The Coach House White Post Rd Bodicote OX15 4BN

Comments on 19/00895/REM - 12 August 2019

Drawing Title
HARD, BOUNDARY & FURNITURE PROPOSALS (SHEET 2 OF 3)

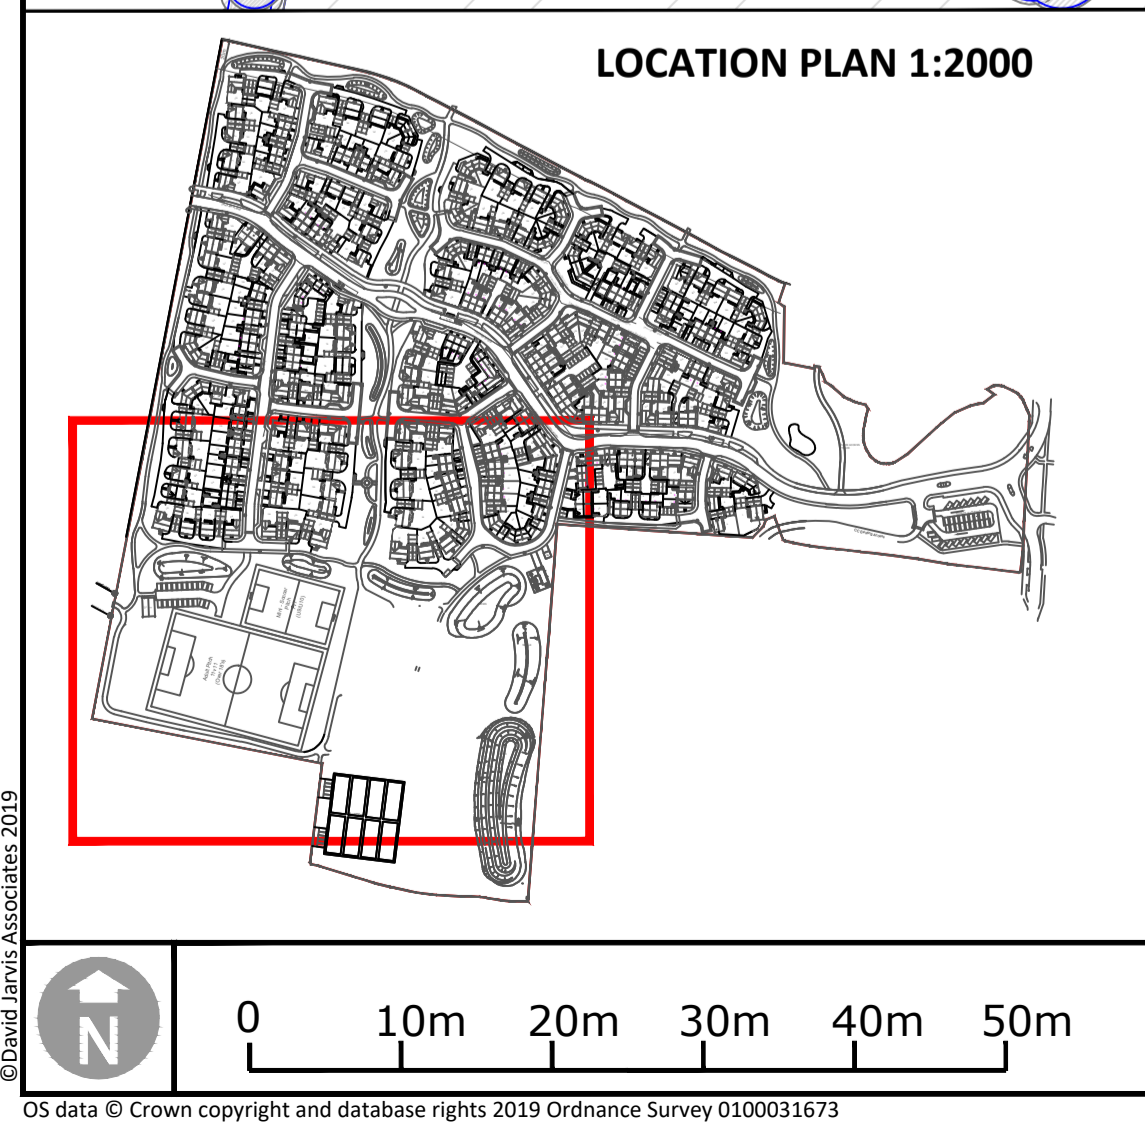
Fencing around Coach House and nursery as discussed with developer and Oxford Diocese and screening of the road.

We were informed at a meeting with representatives of the Diocese and the developer David Wilson Homes that new fencing would be erected and green hedgerow planted on the boundary.

We would like confirmation that the hedgerow is new planting and not an indication our hedge/fencing on our property to be identified as screening.

On the attached drawing we have indicated where we have a gate into our paddock from the field, which we have accessed via the field up to now, which was discussed with the representative of the Diocese and the developers. We would be willing to negotiate repositioning vehicle access to the gate so the paddock can be accessed from a road position rather than driving over green spaces.
